Application No: K/26/21/HH
Site Address: 109 Golden Avenue East Preston BN16 1QT
Description of works: Erection of two storey rear extension with juliet balcony, front porch extension and reroofing of existing front garage

OWQC38420

A :: Proposed First Floor Plan
03 scale: 1:100

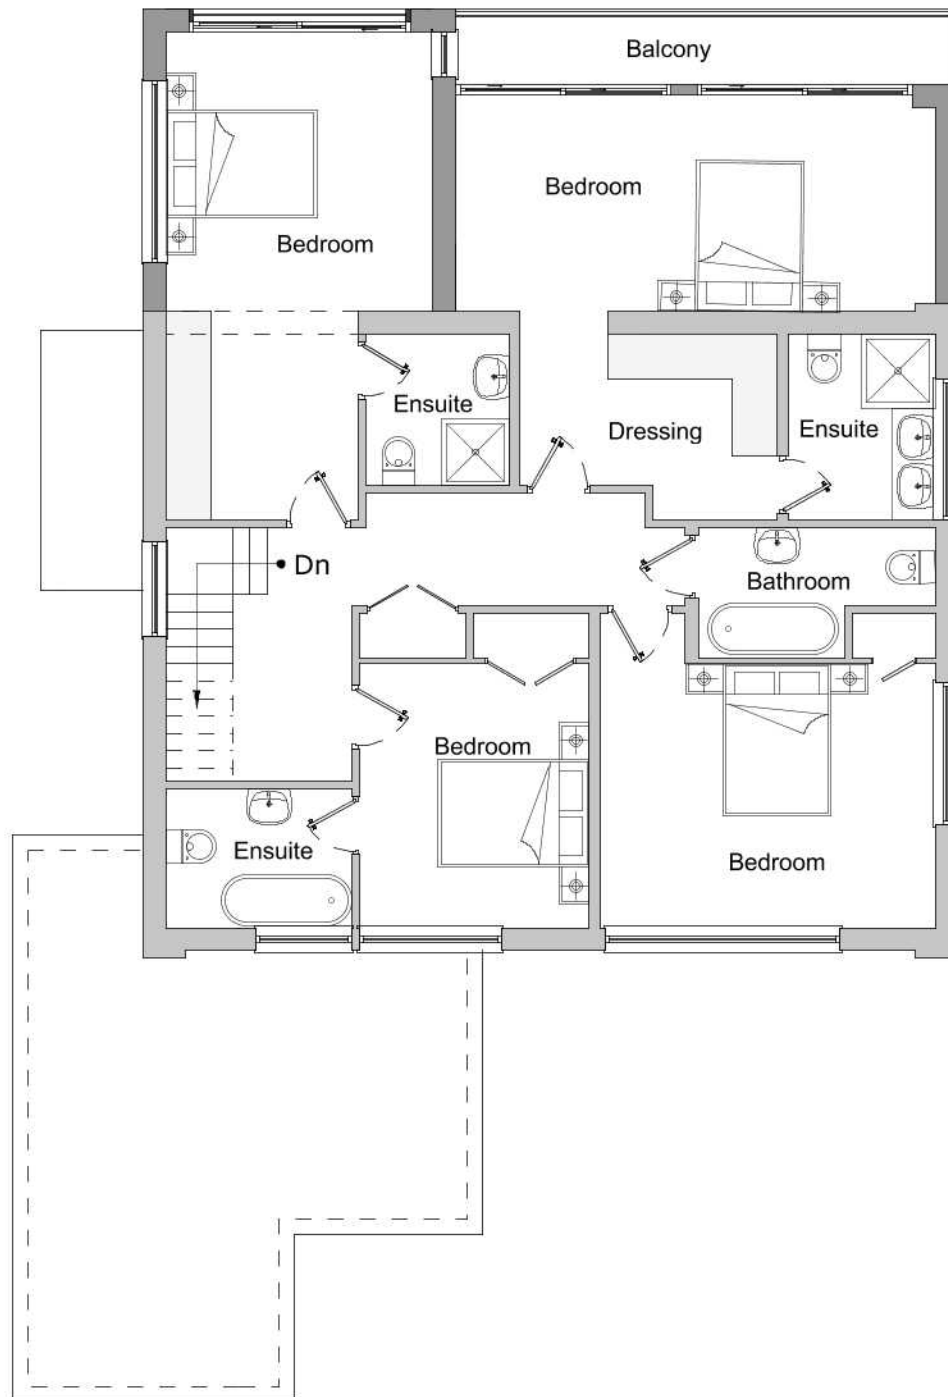
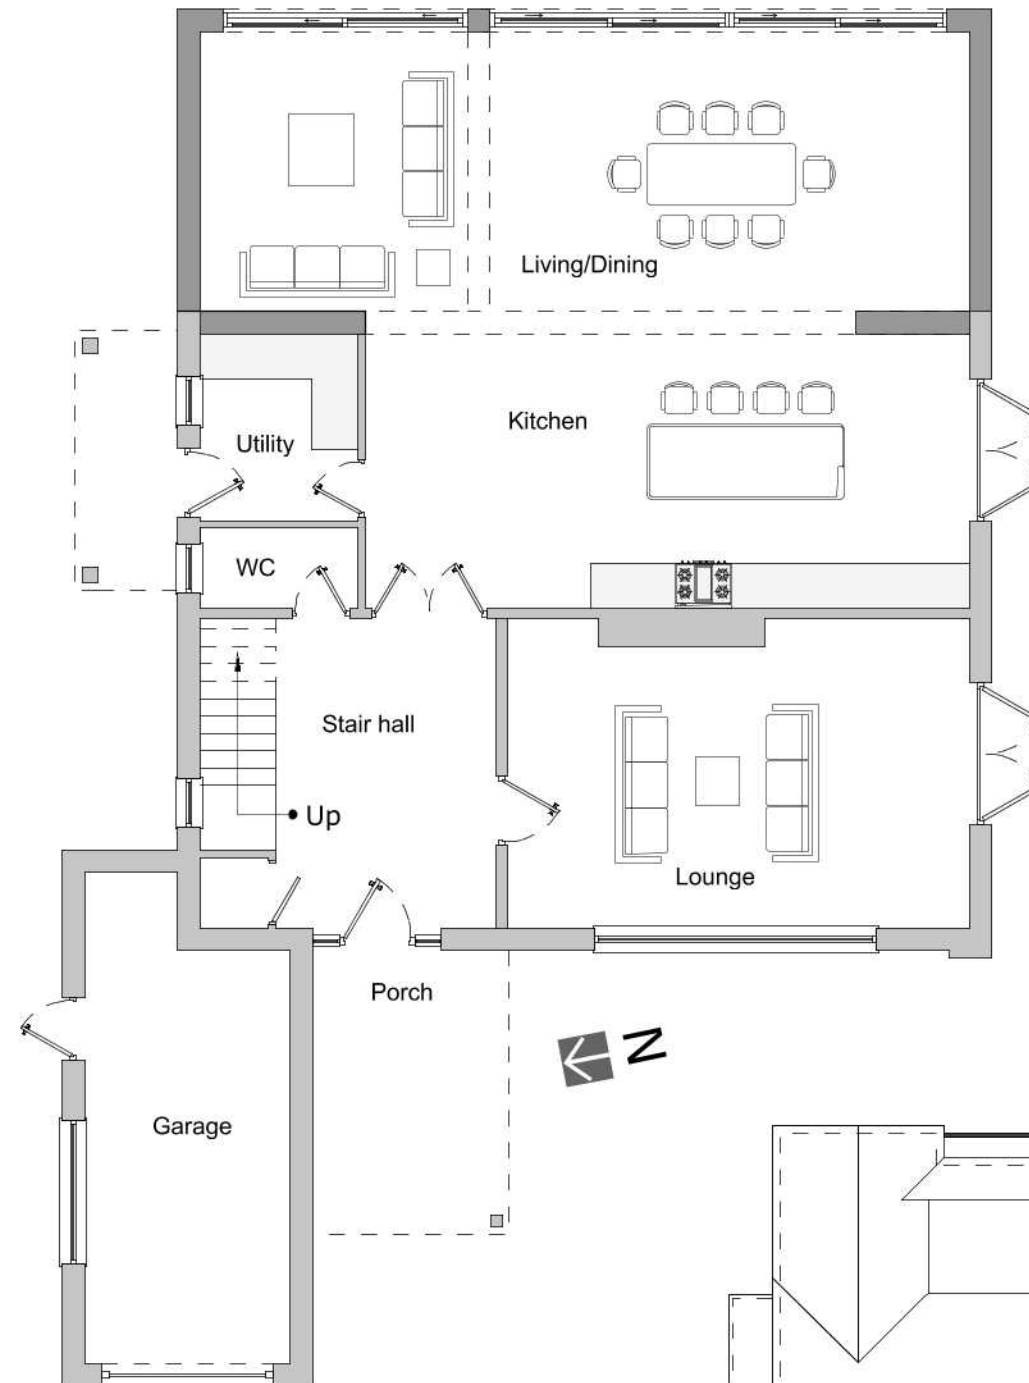
Please consider this revised comment from Kingston Parish Council:
No objection providing the balcony privacy screen is opaque and 1.7m high for the full depth of the balcony
